**Our Case Number:** ABP-314964-22

**Re:** Proposed development of a Circular Economy Campus and an Integrated Waste Management Facility at the Hollywood Landfill  
Hollywood Great, Nag's Head, Naul, Co. Dublin, A41 YE92

Objection  
to an application by  
Integrated Materials Solutions Limited Partnership  
(Limited Partnership No: 1457)  
for an integrated waste management facility  
at Hollywood Great, Nag's Head, Co Dublin

from  
Patrick Boyle, B.E.  
Hollywood and District Conservation Group  
Hands Lane, Rush, Co. Dublin

Figure 5-7 Basal Liner details for Non-hazardous Cells

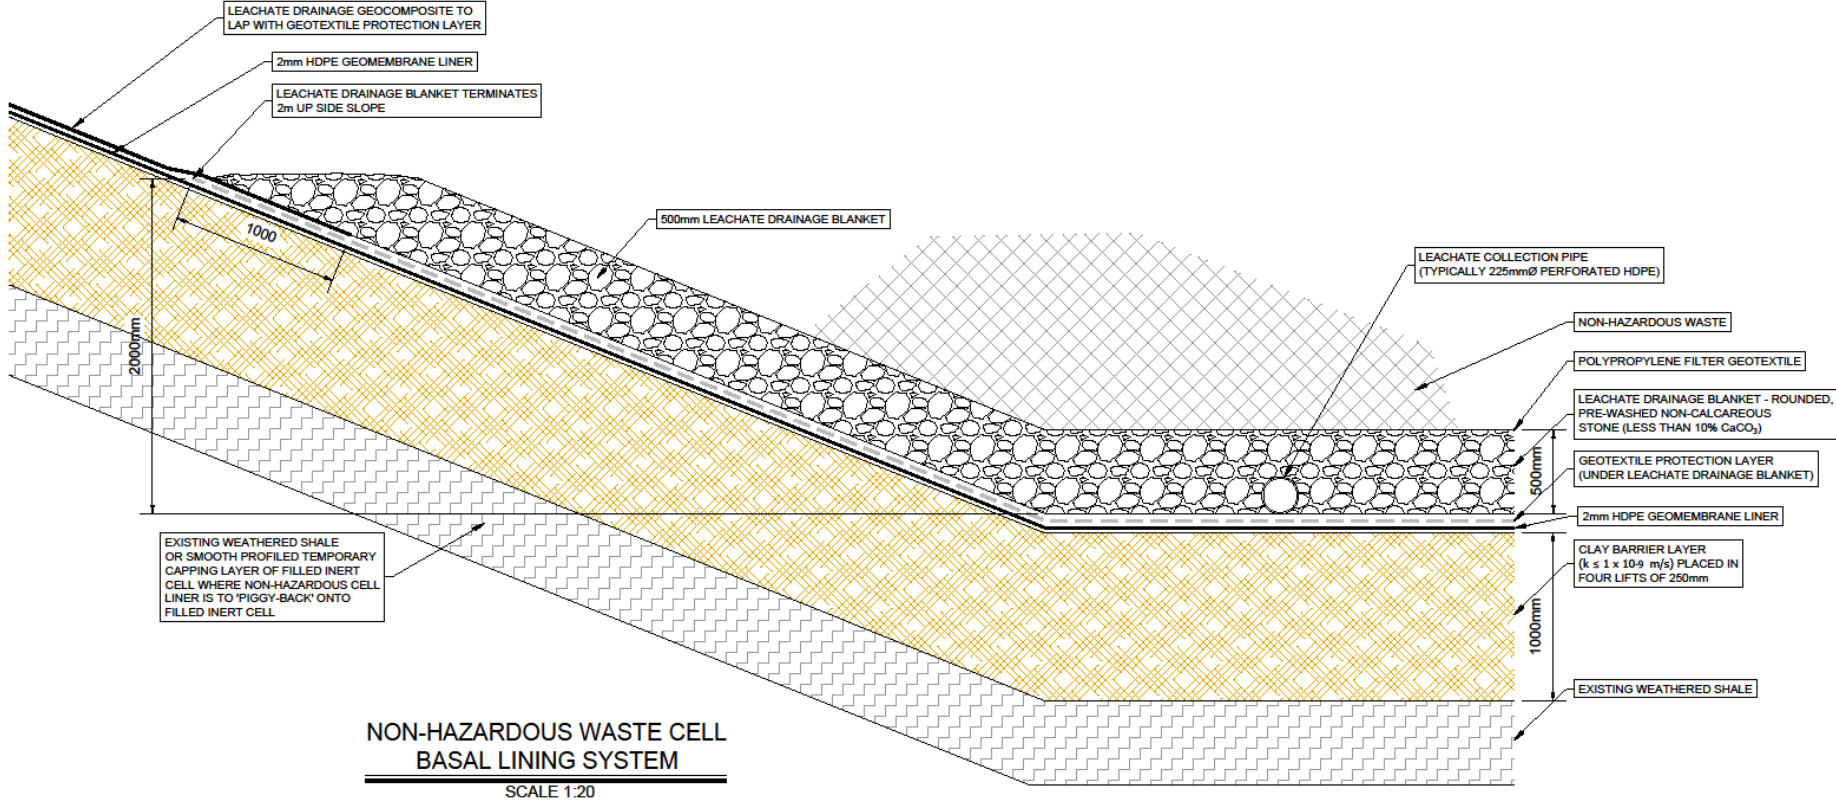
The proposed engineered protection for the cells containing IBA is one meter thickness of low permeability clay, a plastic sheet underlay and a plastic sheet capping. This has been considered by the EPA to be insufficient in the absence of a natural clay barrier. If the protective measures do not fail during the working lifetime of the landfill, they are known to fail in the fullness of time, i.e., after closure. Again, this is prohibited by the Landfill Regulations -the protection applies "during the whole life-cycle of the landfill".

- The applicant claims that an engineered low permeability clay liner 1 meter thick would give the equivalent leachate attenuation of 3 meters of natural clay of higher permeability. As permeability is but one of a number of factors affecting attenuation, the applicant's claims are therefore scientifically incorrect. His proposed engineered liner design is therefore inadequate.

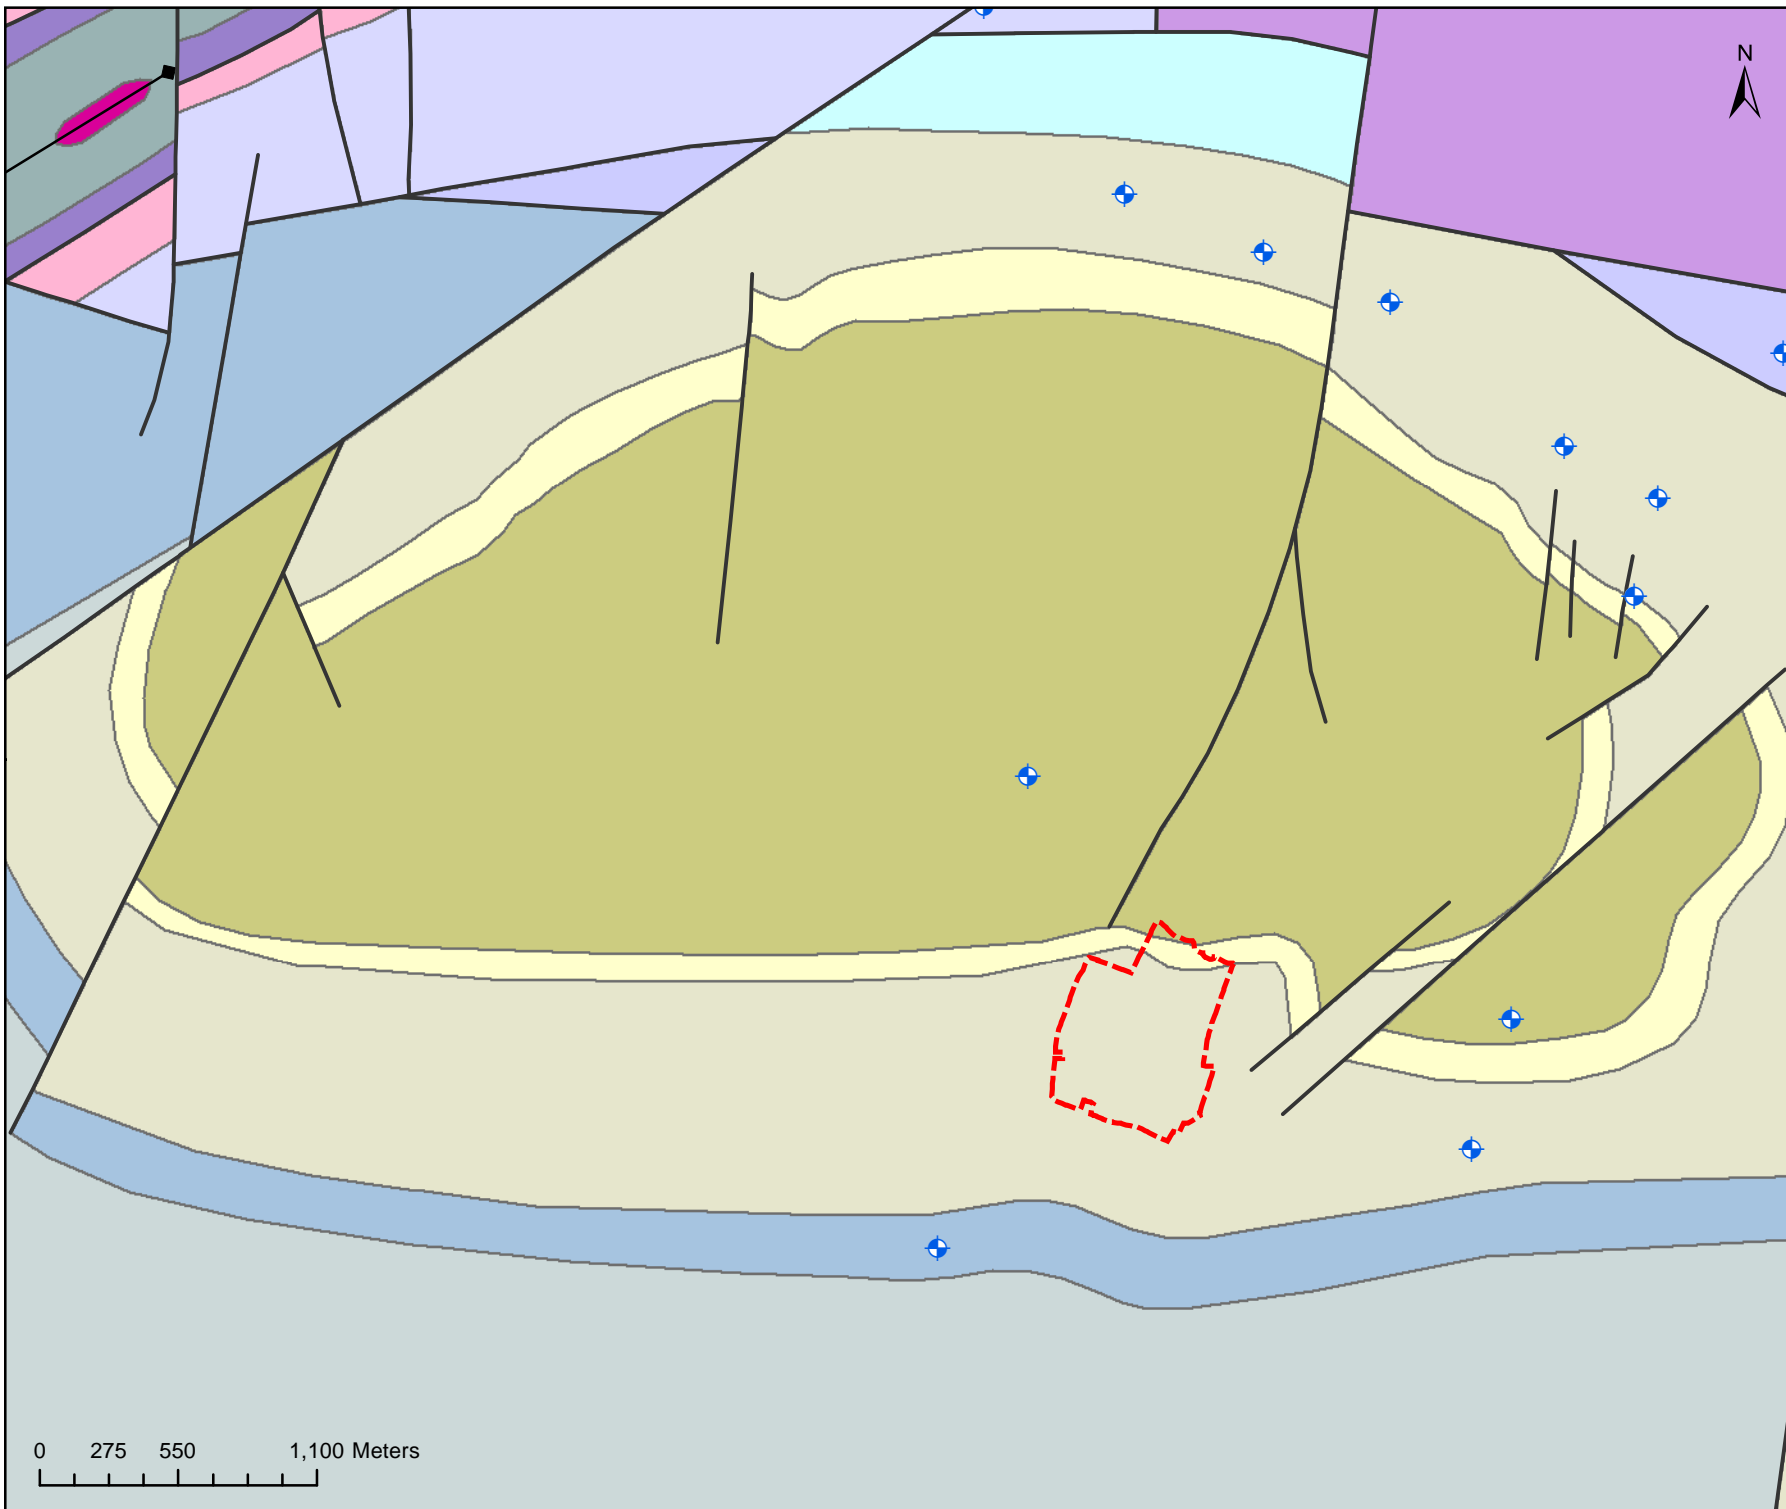
Note: An inaccuracy in the location of this boundary on the GSI map places the boundary too far to the north of the site. The site floor is thus principally Namurian, i.e., classed as a poor aquifer (See corrected site geology map attached). However, site specific investigations have found this rock to be highly fractured and may well be capable of groundwater yields locally in excess of 100m<sup>3</sup>/Day.

**In this he makes no allowance for the error in the GSI site geology i.e. that the waste cells are in fact underlain by the Namurian formation, where groundwater flow is proven to be eastwards, directly towards Hedgestown.**

- The Loughshinny Formation is shown incorrectly too far north on the site. (see Arup corrected site cross-section and aquifer plan attached)
- The GSI map also highlights in Green the Zone of Contribution of the Bog of Ring well field and the position of the southern water divide directly east from the proposed landfill site at Hedgestown.

The issue of groundwater flow patterns immediately to the east of the site is further complicated by the presence of two north east trending faults for which the applicant has also provided no data. (See GSI Geology Map attached).

File Identifier: MDR1492A-RPS-00-XX-DR-Z-AG-0014		
Status: S0	Rev: P01	Model File Identifier:
Drawn: MV	Date: 16/09/2022	
Checked: SA	Scale: N.T.S. @A4	
Approved: PC	Projection: ITM

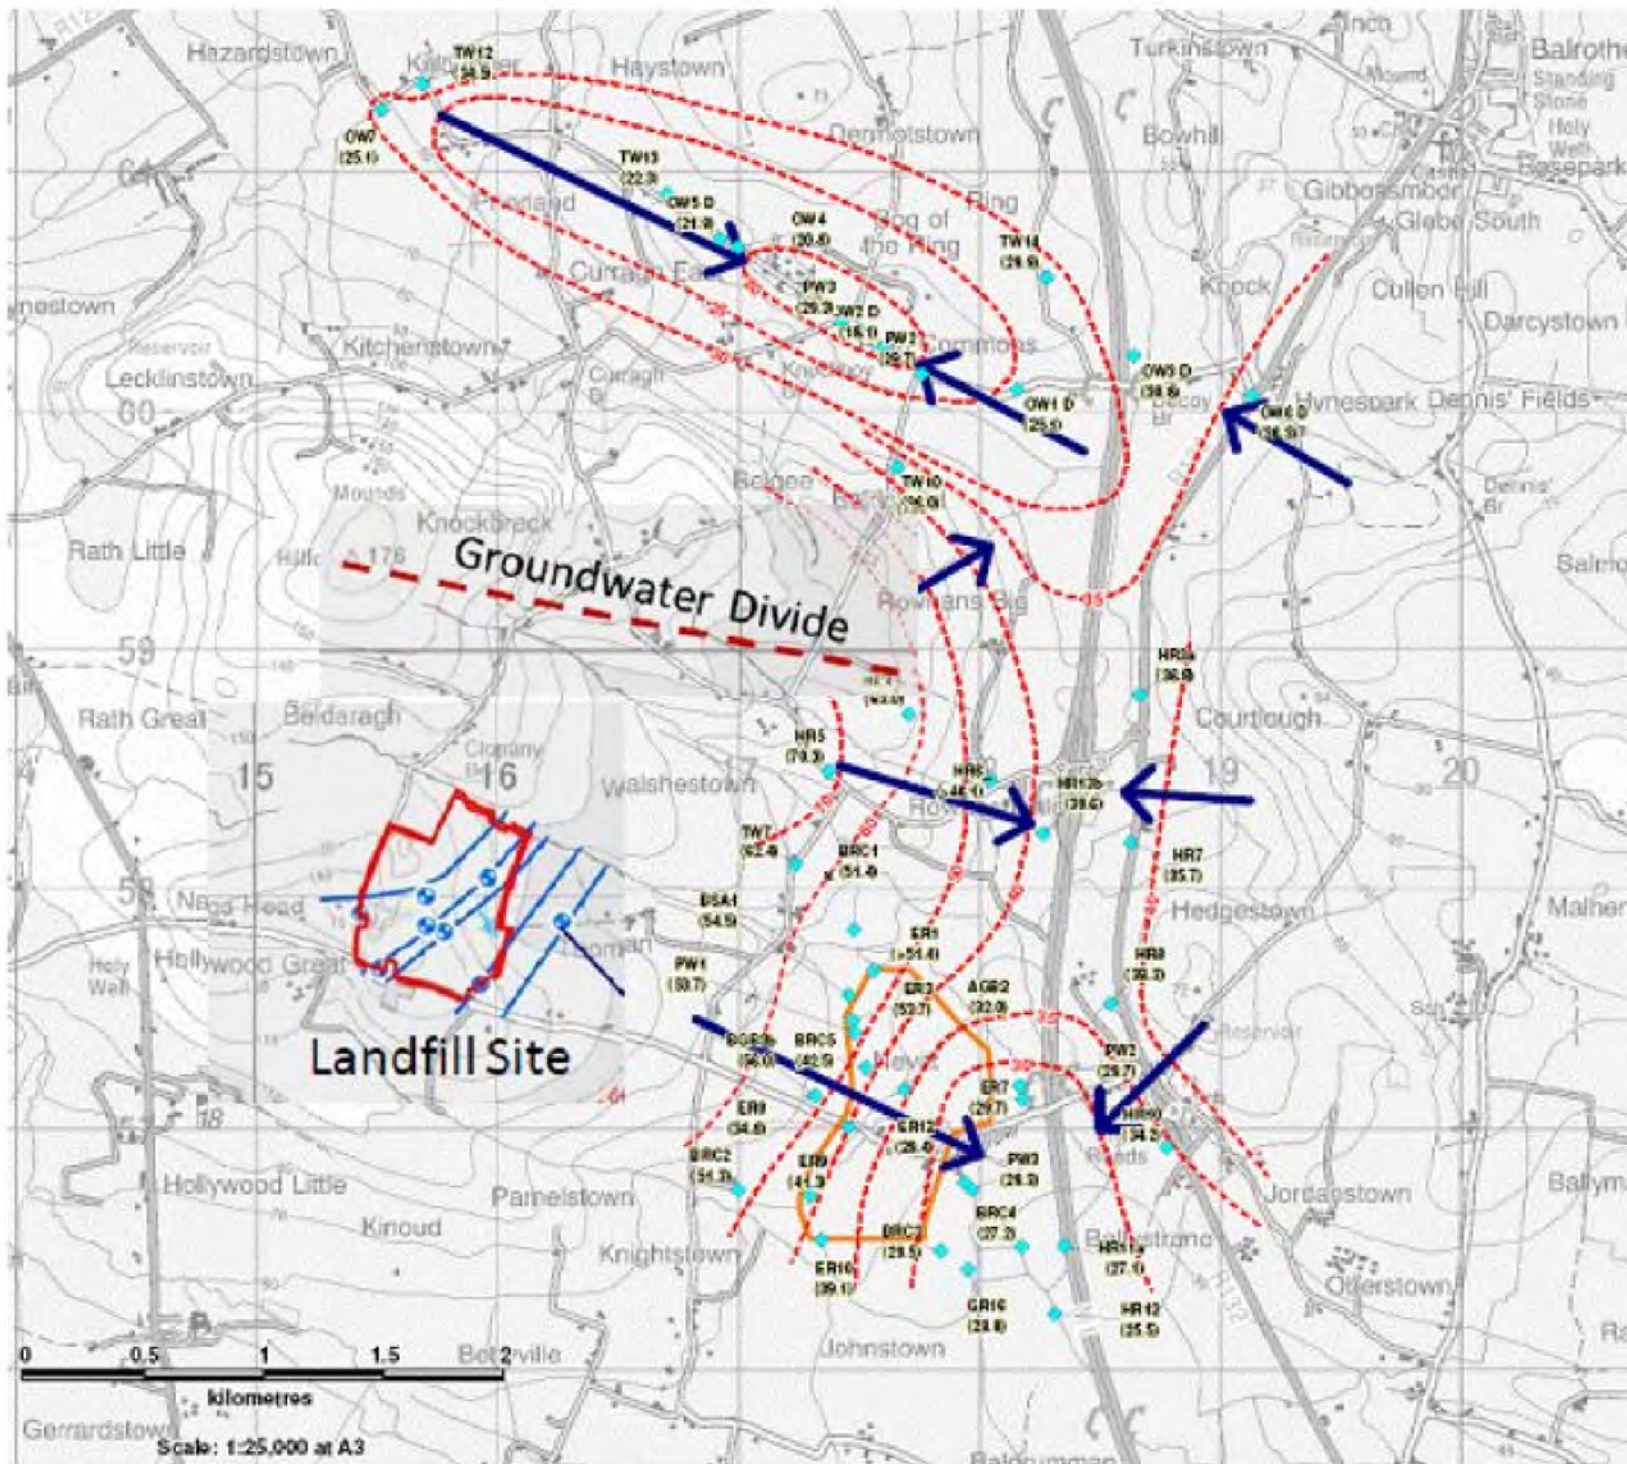
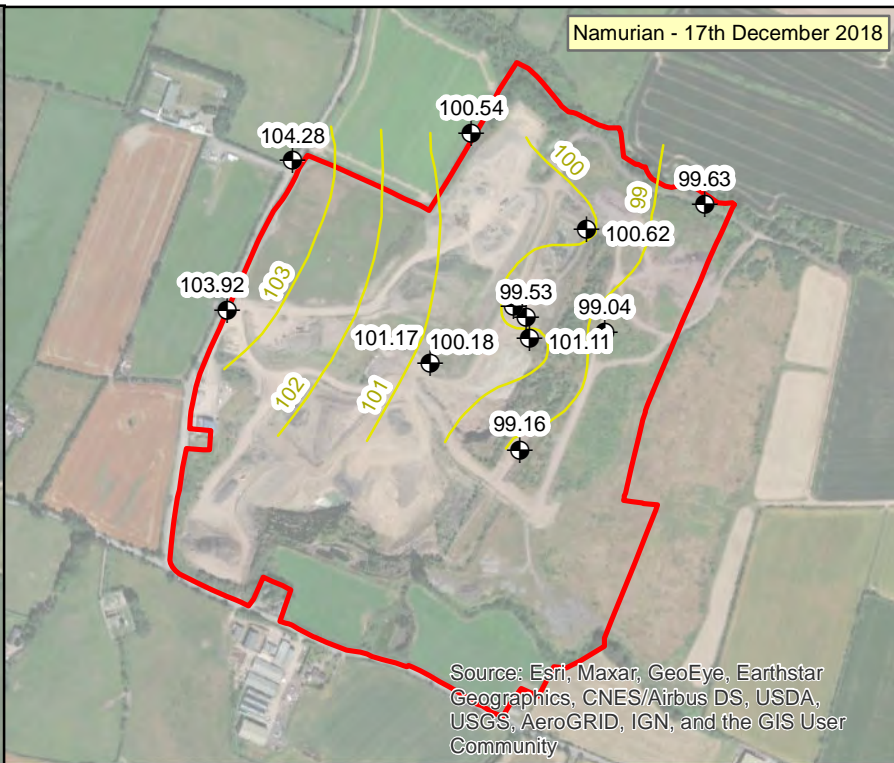
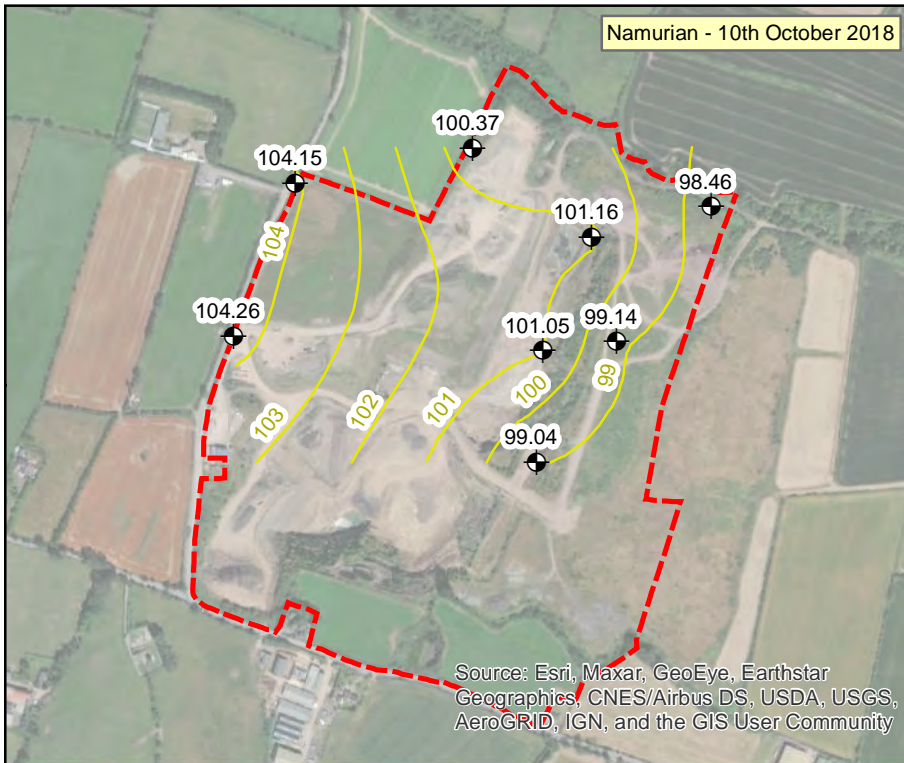
CDM Smith consultants conducted a site-specific study of the site for the applicant and produced groundwater level contours for the Loughshinny and Namurian formations. The resultant contours are shown attached.

They clearly demonstrate that the groundwater flow in the Loughshinny formation is to the southeast but the Namurian is likely to be eastwards, i.e. directly towards Hedgestown.

An examination of Namurian borehole data produced by Arup also demonstrates a slightly north easterly flow (see attached).

Note: In the absence of any borehole data to the east of the site being provided by the applicant, I have drawn provisional groundwater and surface water flow direction arrows eastwards based on topography. (see attached)
